# **HURSTVILLE PRIVATE HOSPITAL**

**ACCESS REVIEW**

**Morris Goding Accessibility Consulting**

5<sup>th</sup> September 2012

TITLE:
PROPOSED GROUND FLOOR
PLAN

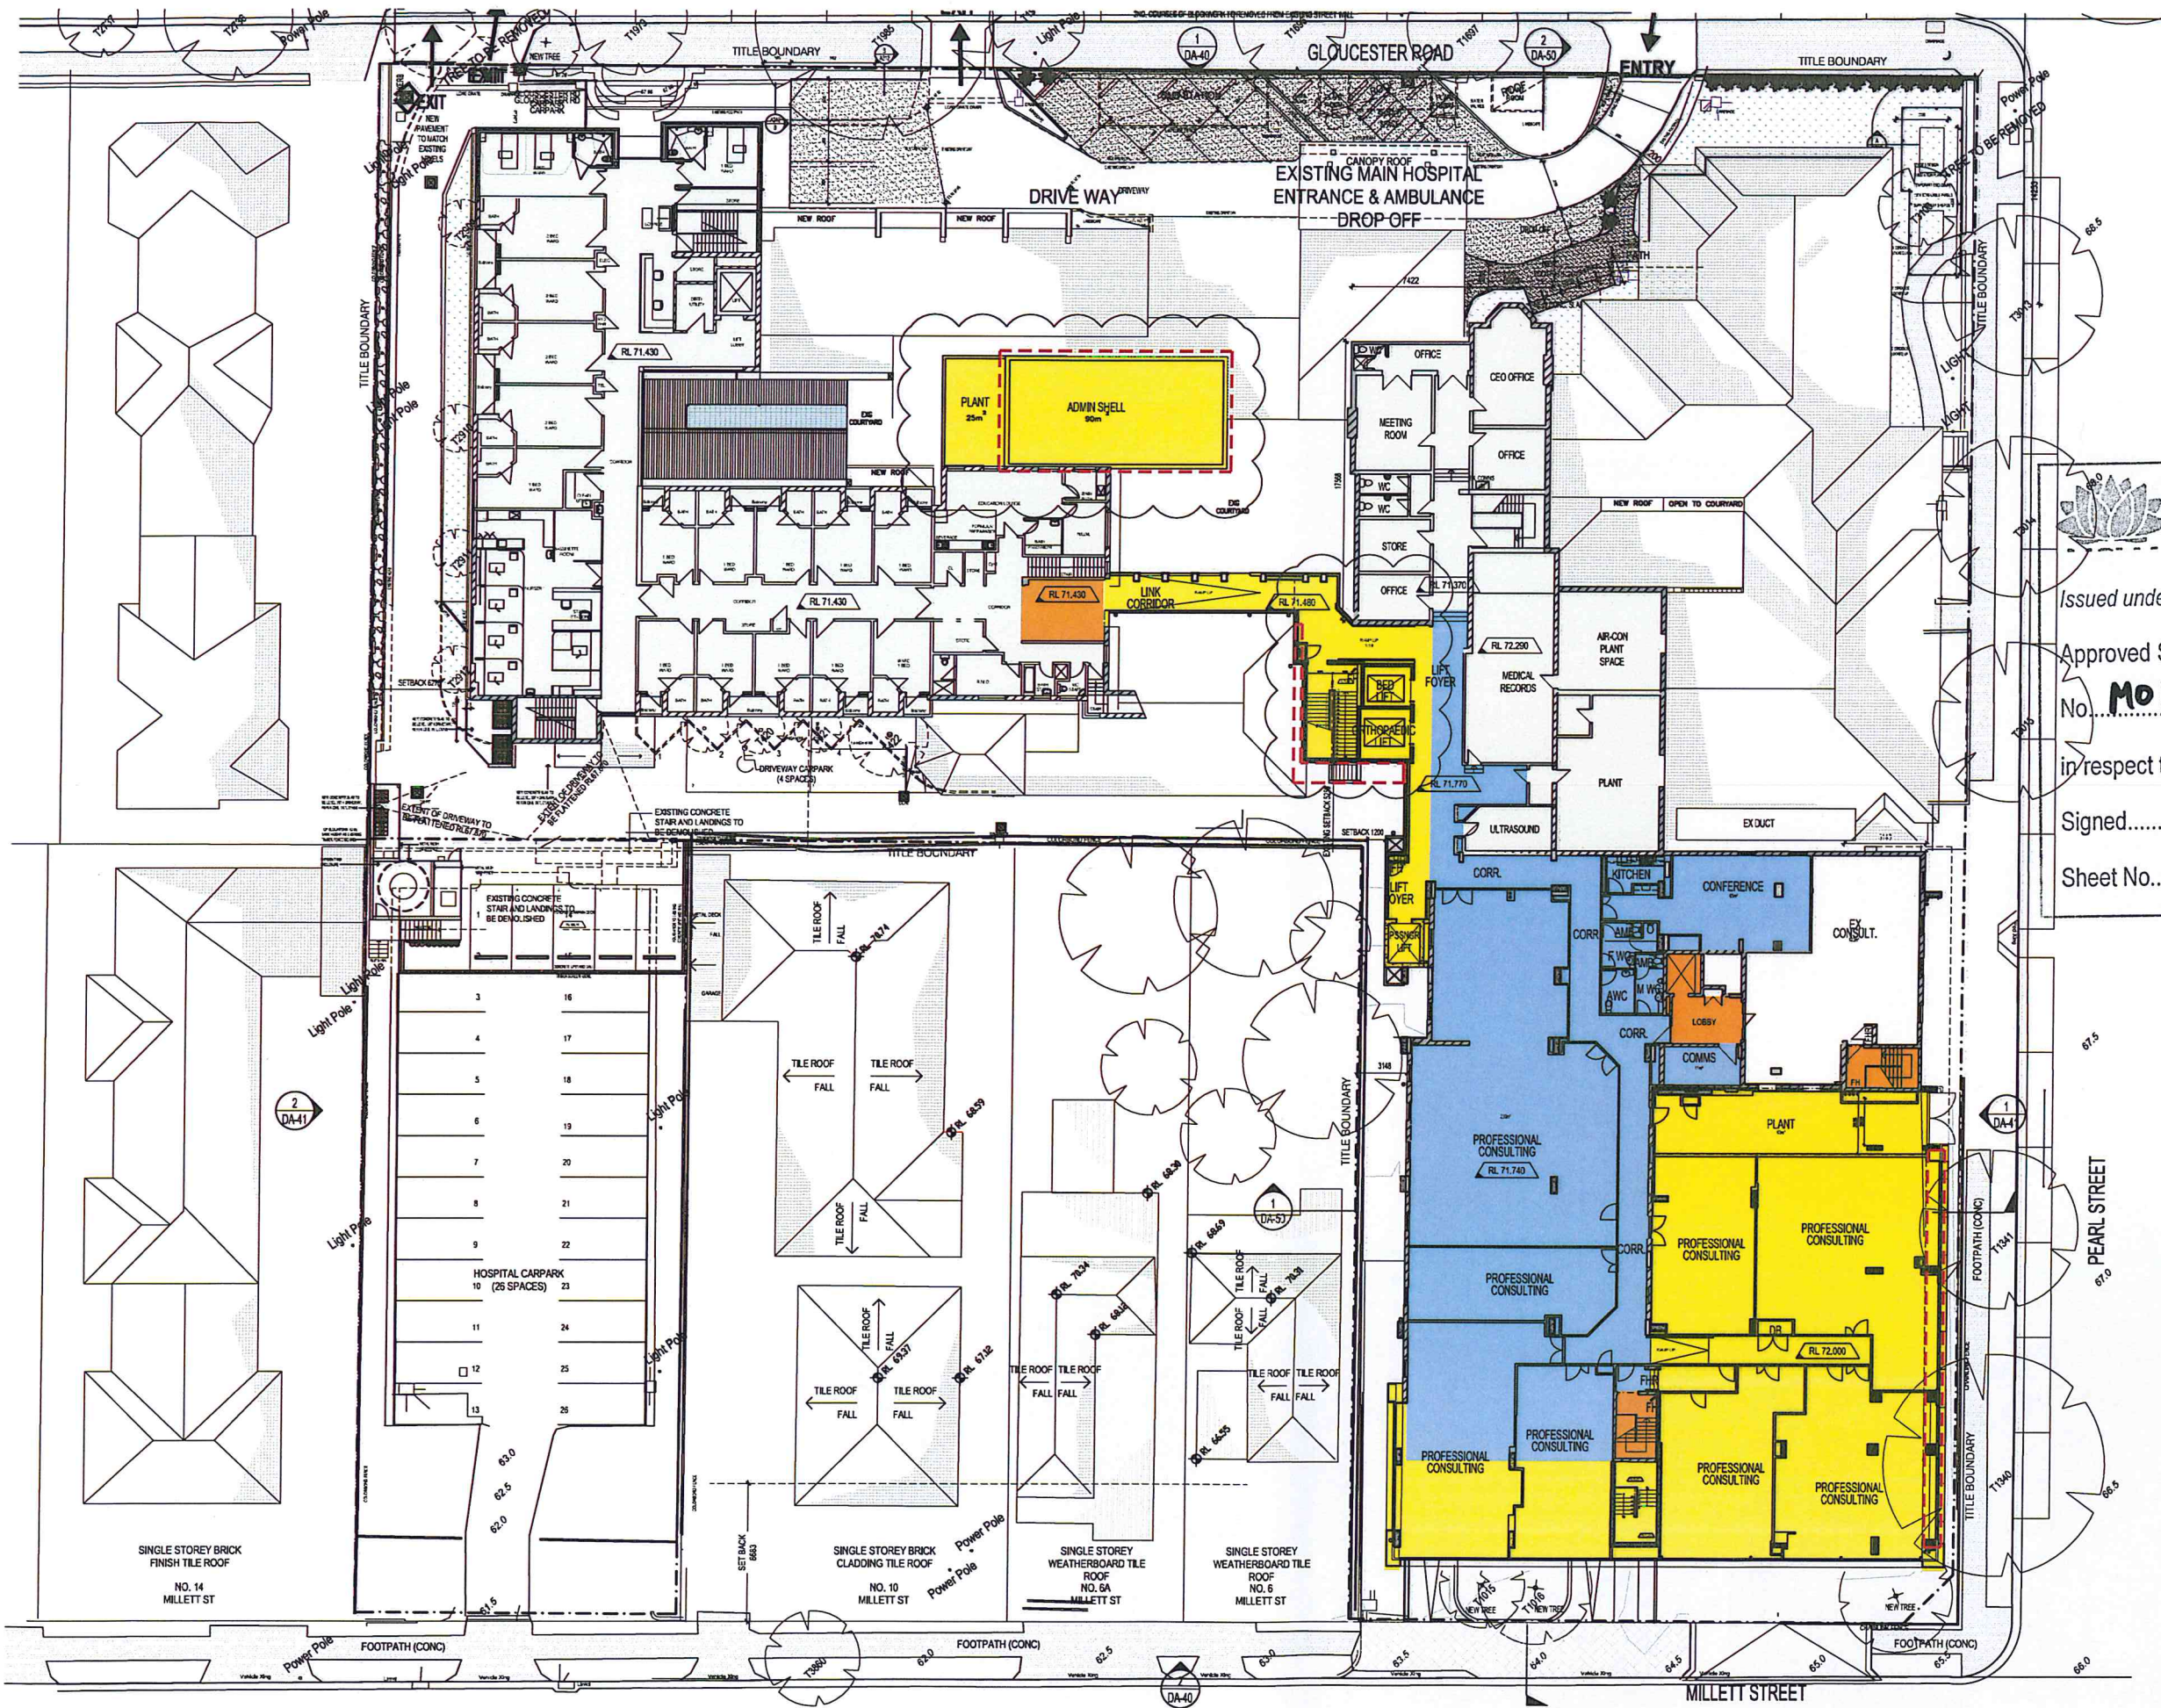
The drawings provided indicate that the main corridors from Gloucester Road entry lobby to existing northern lift, new central lifts and new works at the ground level of the building have suitable clear widths of approx. 2000mm compliant with AS1428.1. These widths will allow people who are using wheelchairs the space to perform a 180 degree turn, and enable 2 people who are wheelchair users to pass each other, compliant with DDA Premises Standards and AS1428.1.

Some existing dual hinged doors on main corridors appear to have an active leaf of less than 850mm clear width opening. These will require review for compliance with AS1428.1 unless they are smoke doors and permanently fixed open (magnetic locks).

There are some corridors within the new Day Surgery Area (ground floor) that appear to have widths of less than 1500mm. This requires review to ensure suitable turning and passing areas for wheelchairs as required by the DDA Premises Standards and AS1428.1.

- (i) Provide increased turning areas (1540mm min. width x 2070mm min. length) within 2m of all new corridor ends (eg. Day Surgery: outside OT lounge, Open courtyard, ground floor) to allow a person who is a wheelchair user to perform a 180 degree turn, compliant with AS1428.1.
- (ii) Ensure all paths of travel (eg. between fixtures and large furniture items) are 1200mm min. width, compliant with Hurstville DCP, AS1428.2 and AHFG.
- (iii) Ensure handrails are provided along at least one side of every passageway or corridor that is used by patients. Where practical the handrails shall be continuous for their full length, compliant with BCA section D2.17.

There are some double doors (eg. near Lift lobby, Stage 2 Recovery at ground level) that have less than 850mm clear width opening which requires review for compliance with AS1428.1.

- (i) Ensure all double doors have 850mm clear width opening each in accordance with AS1428.1 (unless smoke doors, permanently fixed open on magnetic locks).

- (ii) Ensure all new doors have an active leaf of 850mm clear width opening and suitable door circulation space, compliant with AS1428.1.

TITLE:
PROPOSED LEVEL 1 PLAN

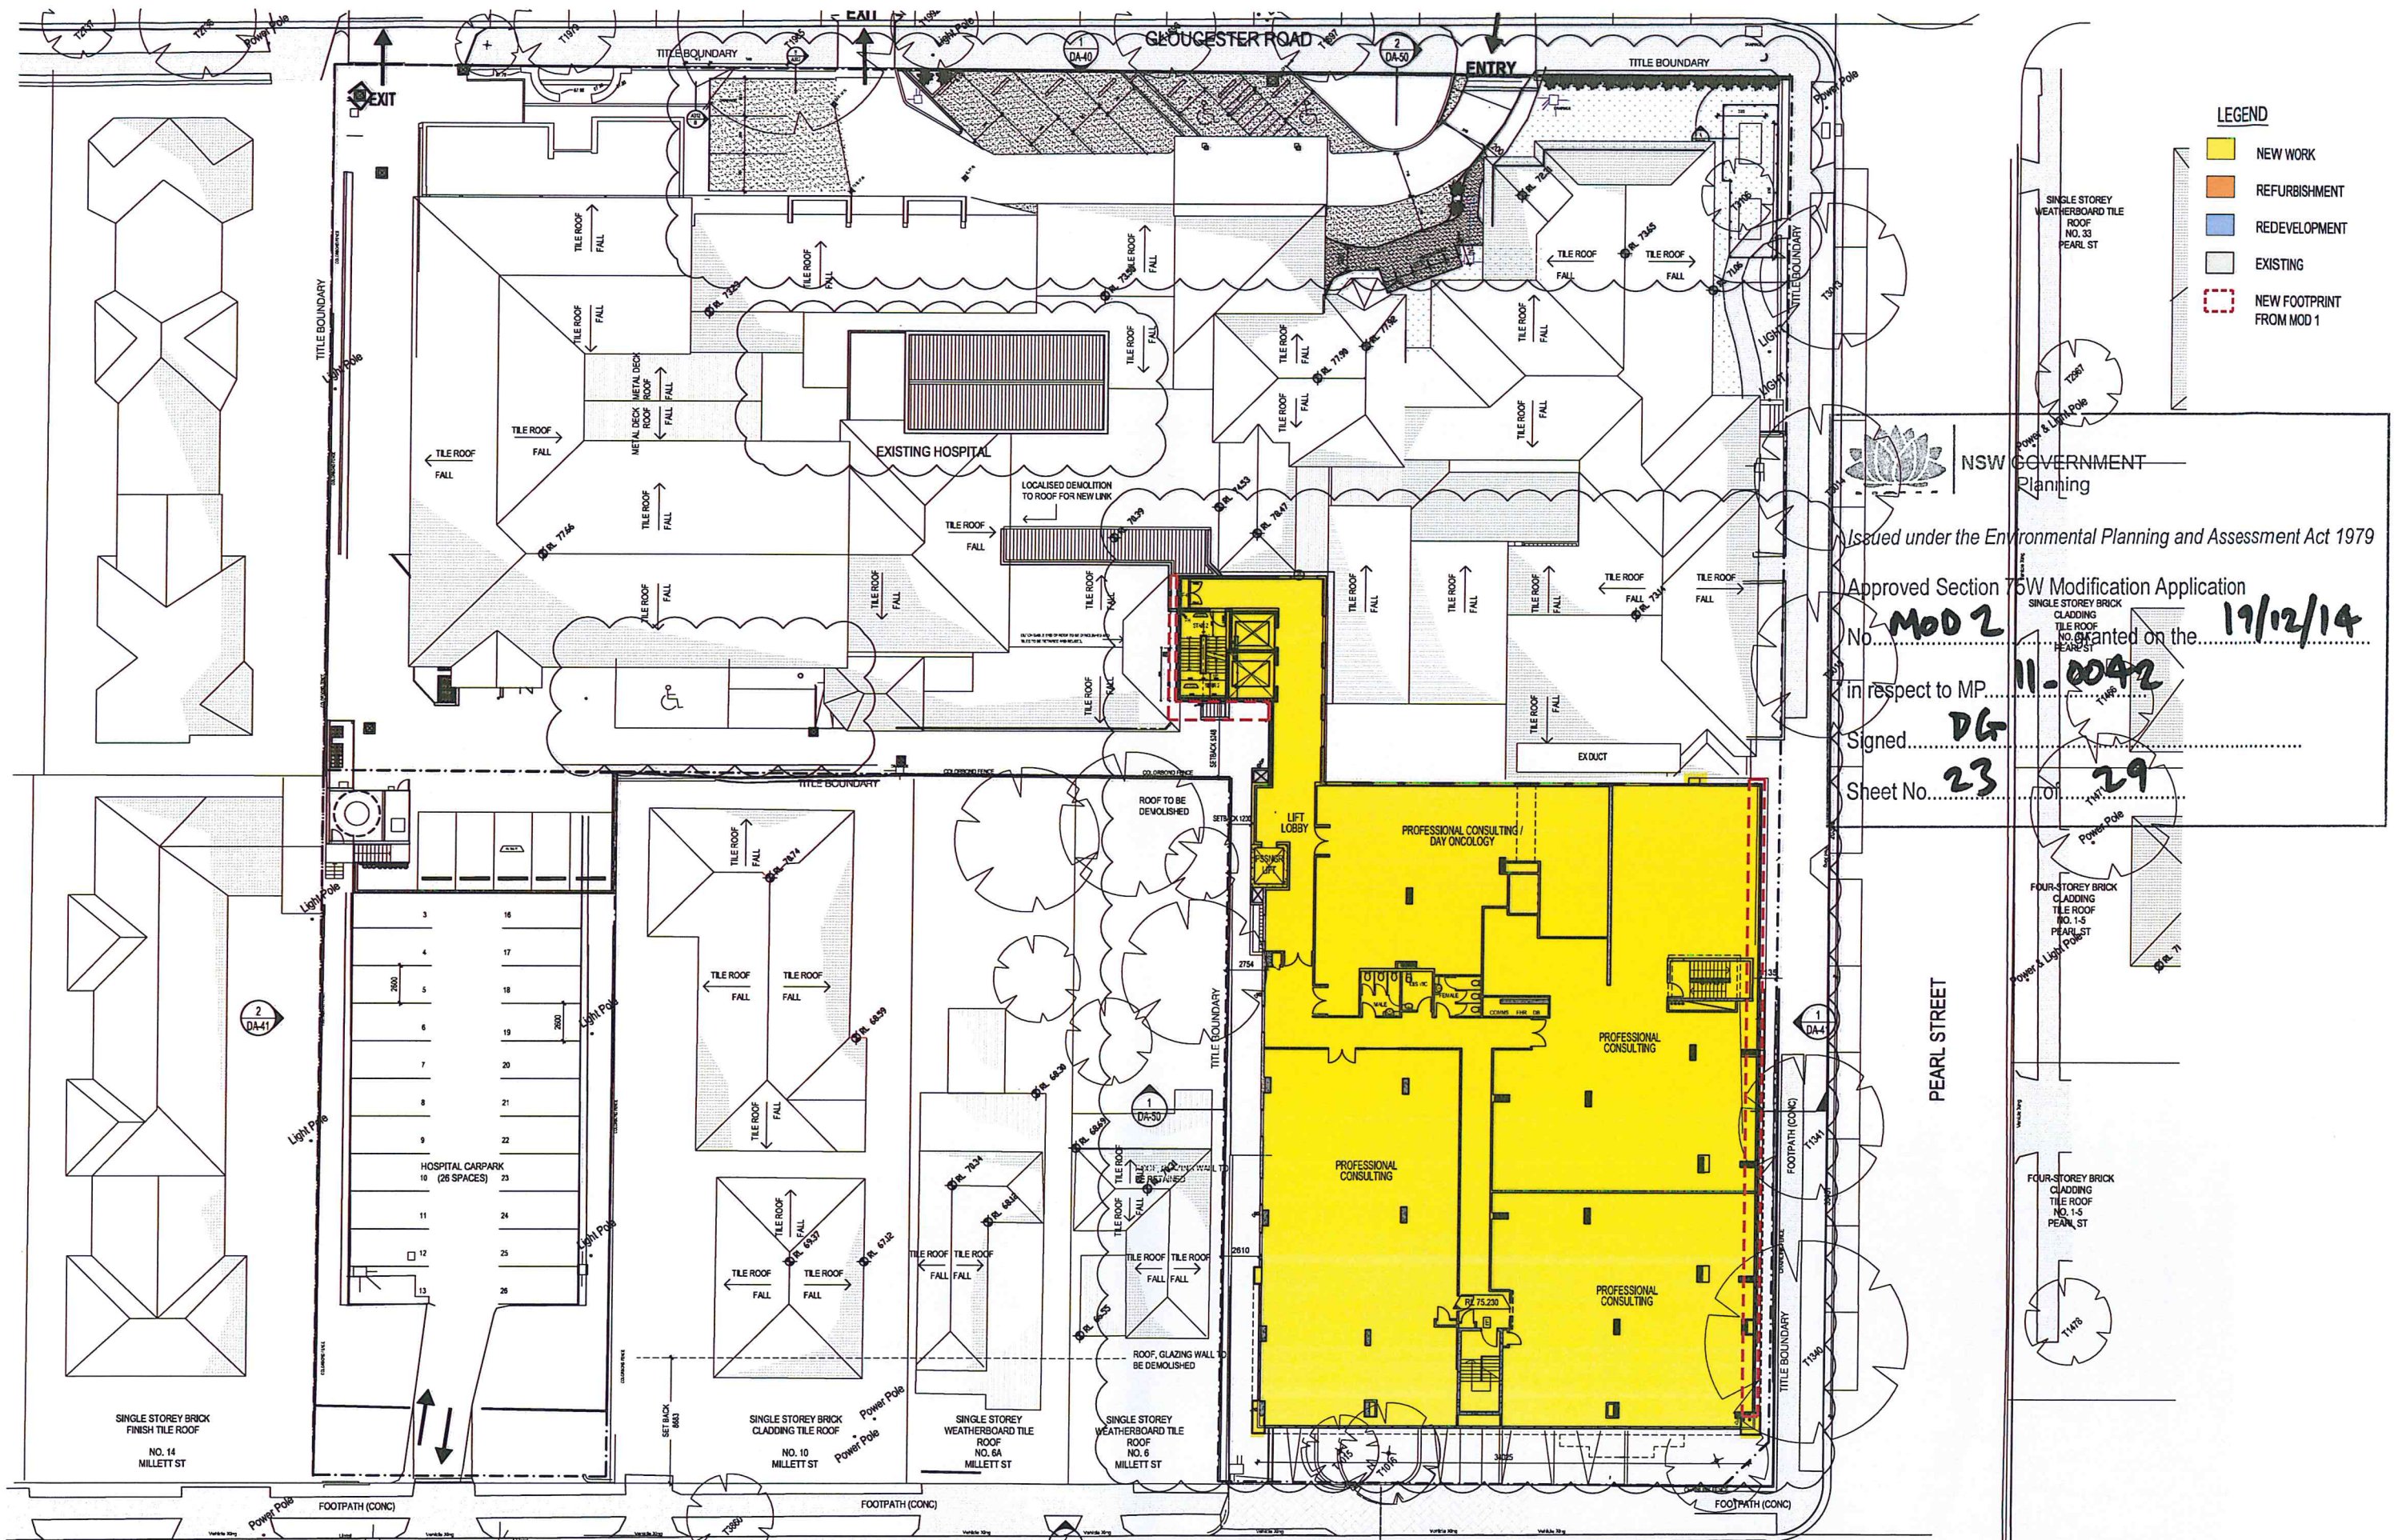
The northern lift will continue to serve the ground and level 1. It provides the accessible path of travel (Affected Part) from ground level to new works on level 1 of building, as required by the DDA Premises Standards. It is suitably located with direct access from the main corridor to be accessible by people with a disability.

The northern lift lobbies will allow for sufficient manoeuvrability for wheelchair users outside the lift car doors, compliant with AS1428.1. This passenger lift has

approx. internal dimensions of 1750mm width x 2400mm length that are in accordance with DDA Premises Standards, BCA E3.6 and AS1735.12.
